Your Ref: OWPC14267
Our Ref: BR/133/17/HH 15-05-2017
Please ask for:
Richard Temple

Boundary fence
31 Frith Road Bognor Regis

PROPOSED BOUNDARY FENCE AT 31 FRITH ROAD, BOGNOR REGIS
FOR MR. & MRS. J. CIOK.

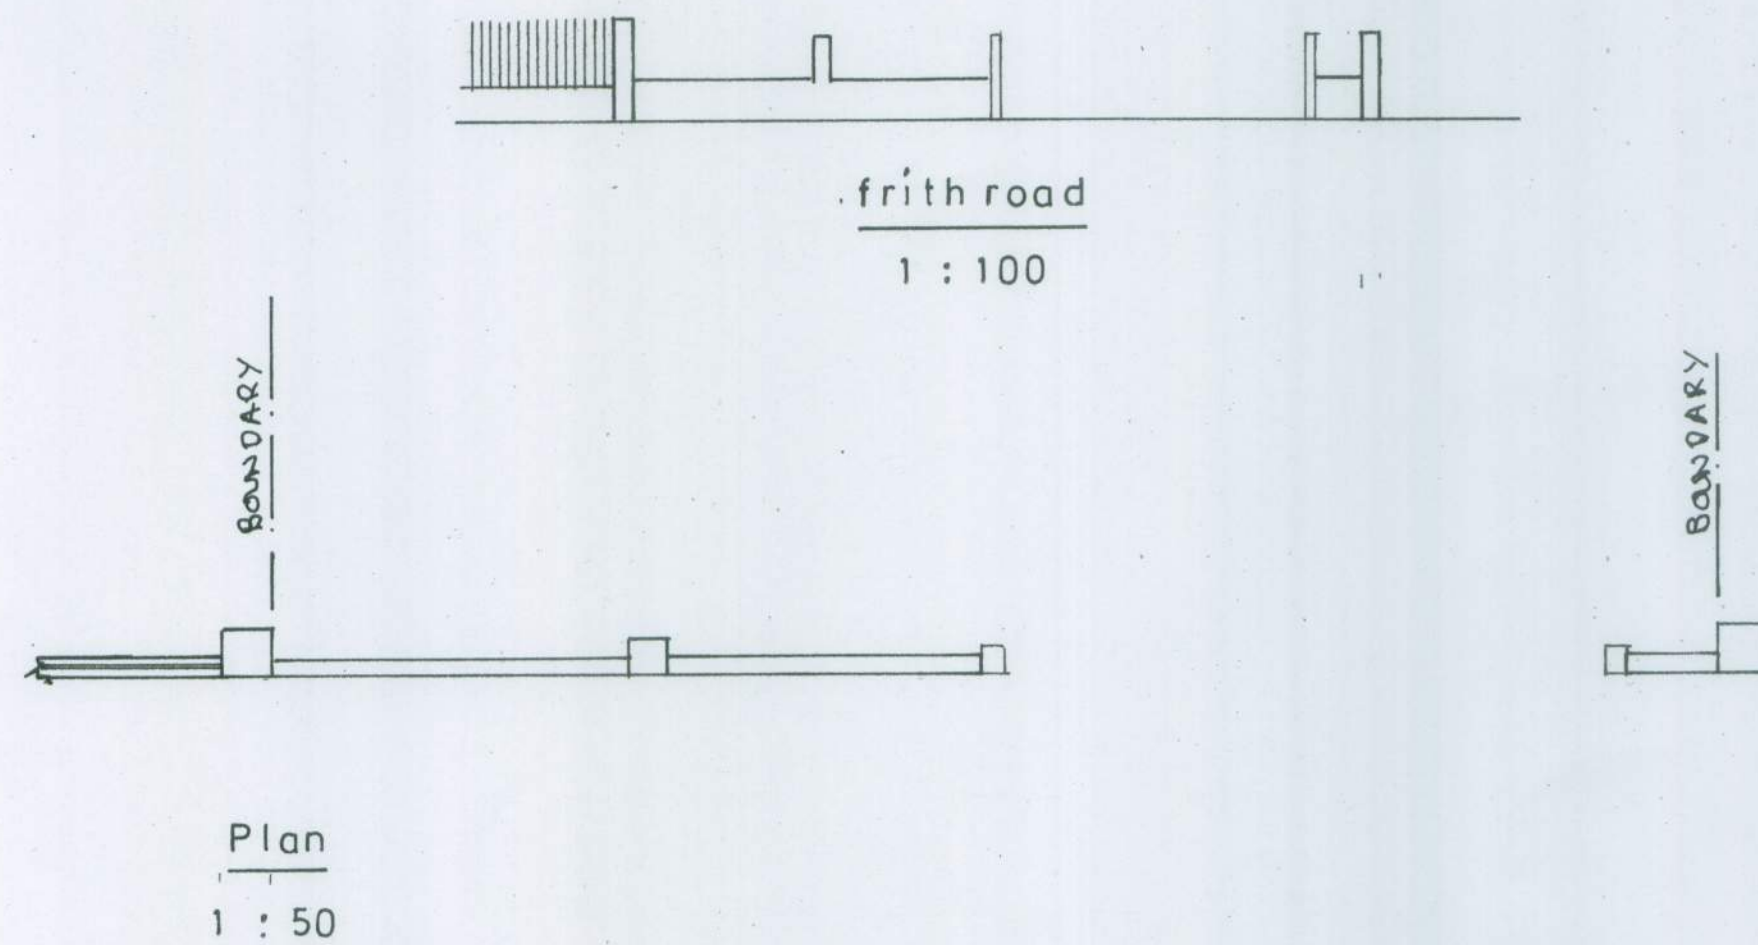
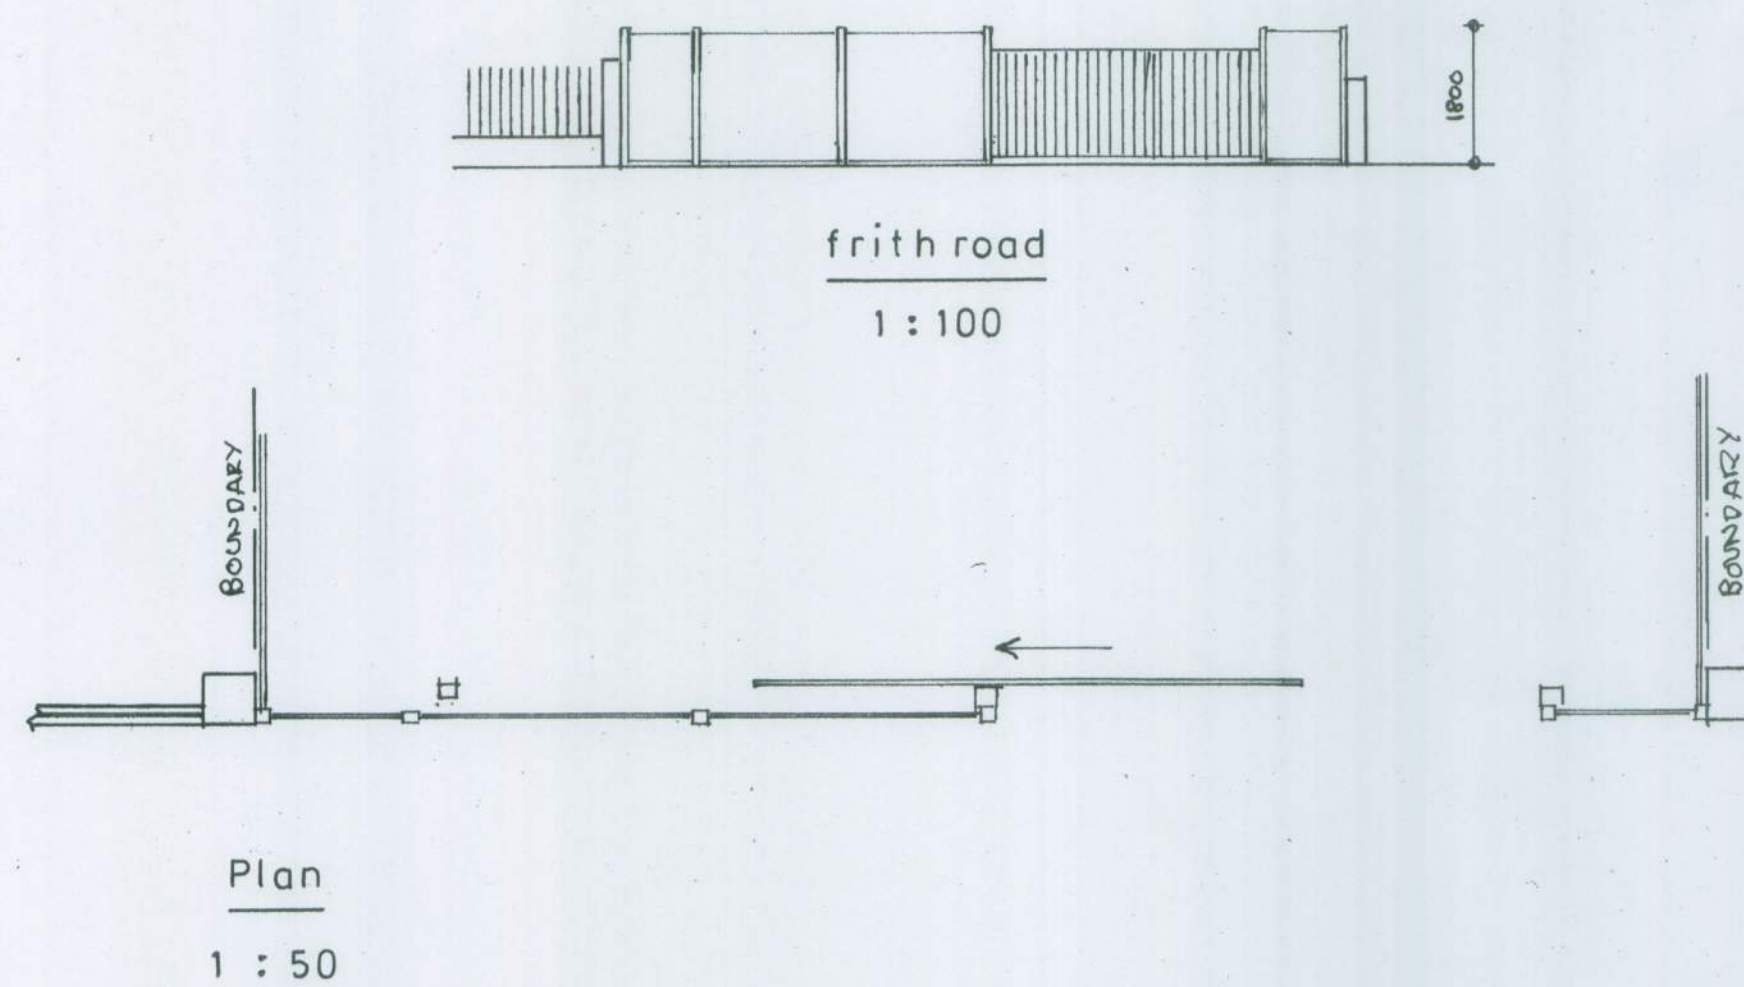
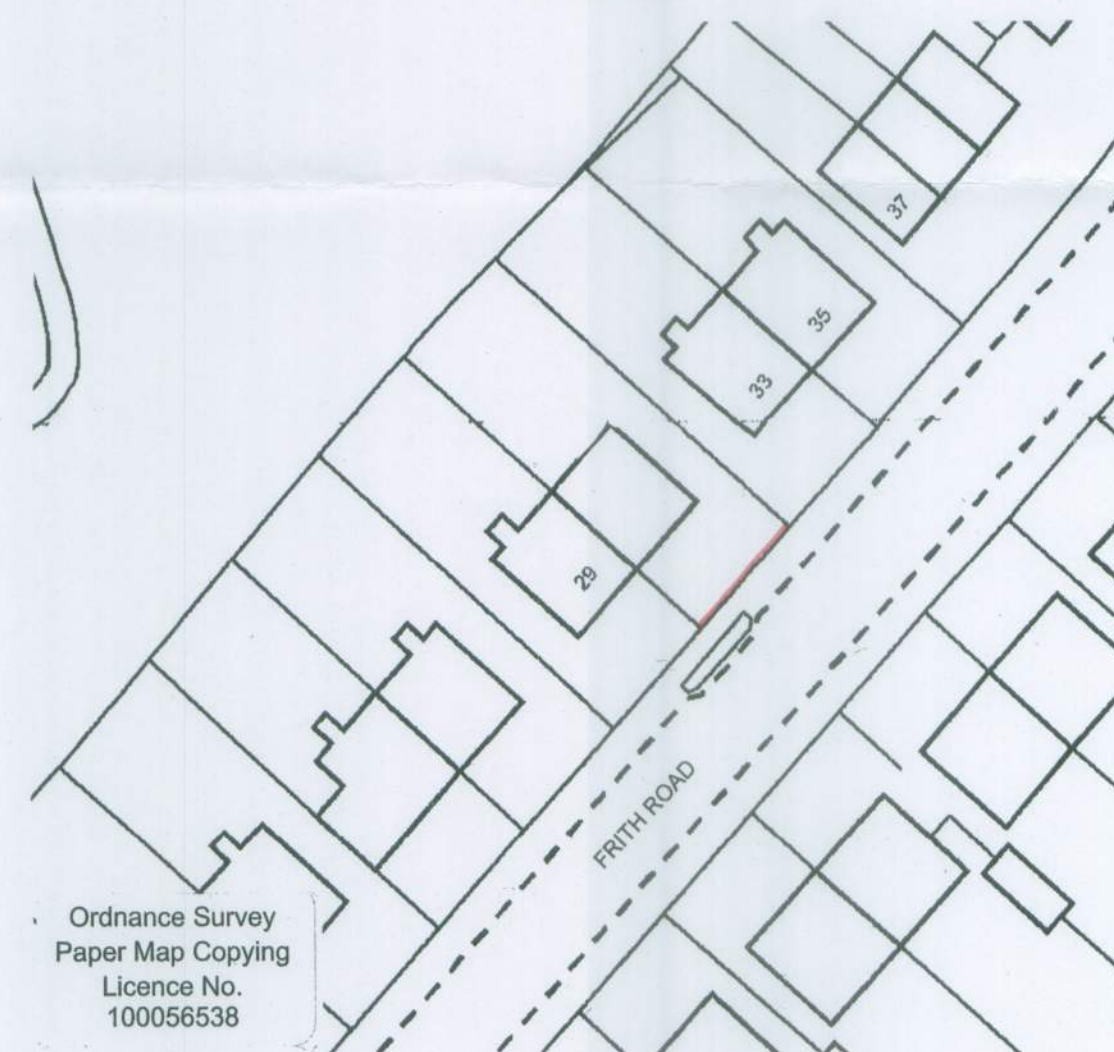
I would like more information regarding how the proposed changes to the boundary will affect the trees and planting along the boundary at the front of the house on my side of the boundary. It is unclear from the drawings. Number 29 is adjoined to 31.
